From: Jane Hunt [REDACTED]
Sent: 27 May 2020 12:48
To: Andrew Wood <Andrew.Wood@arun.gov.uk>
Subject: Planning Application ref: LU/117/20/HH

I have seen the plans. The building is proposed to come right up to my boundary. I am concerned that a two storey extension will cut out a lot of sunlight coming into my garden.

PROPOSED GROUND
FLOOR PLAN

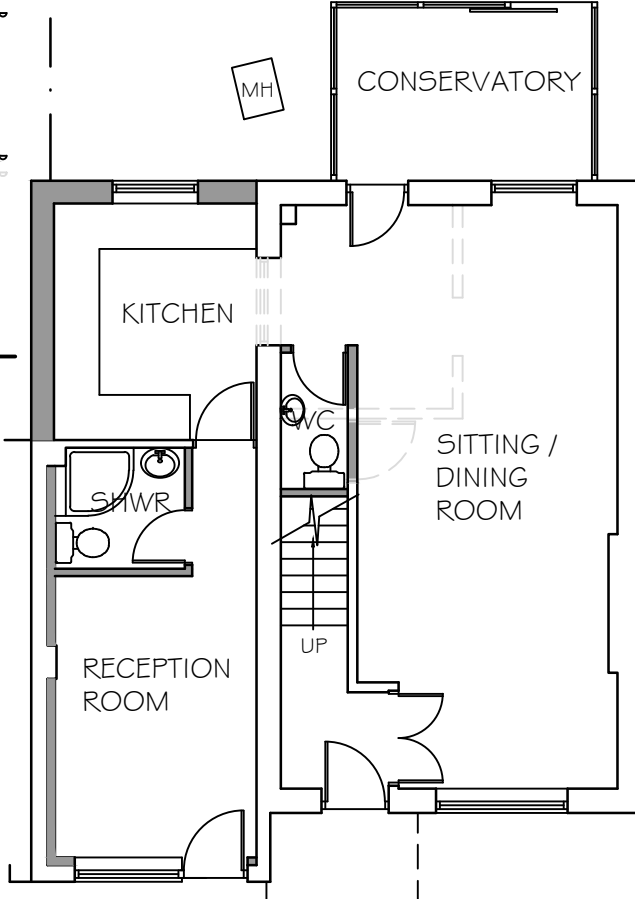
Why 2 front doors? Is it that the extension will eventually become a self contained annex for extra family?
It is theoretically a 6 bedroom house!
